**WEST SUSSEX COUNTY COUNCIL
STRATEGIC PLANNING CONSULTATION**

SUBJECT: A/82/12 - Residential development comprising 150 x dwellings including 30% affordable with access, landscaping, open space & associated works (this application is a Departure from the Development Plan).

Land East Of, Roundstone Lane, Angmering, West Sussex, BN16 4AL

The junction diagram reflects the last run of ARCADY.

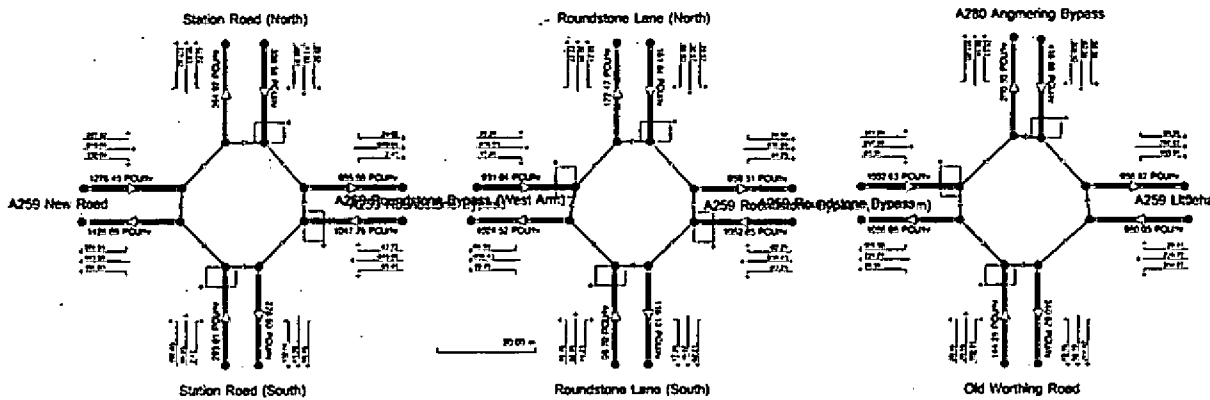
Junction assessments: These do not appear to be consistent with observed traffic conditions on the A259 or at Water Lane/A283. The queue lengths in Appendix 11 appear to be lower than actual observed queue lengths during the morning and evening peak hours. Further detail should be provided on the junction assessments relating to the A259 to explain the relationship between observed congestion and the technical junction assessments. The A283 Angmering Bypass/Water Lane junction is also subject to congestion with traffic queuing (for example) from the traffic calming build-outs on Water Lane to the junction, causing the right-turn lane on the A283 to exceed capacity.

The junction of the A259 and Roundstone Lane appears to have a narrow exit arm from Roundstone Lane which reduces capacity on the arm. Further information should be provided on this aspect of the junction and whether alterations to the kerb line would be beneficial.
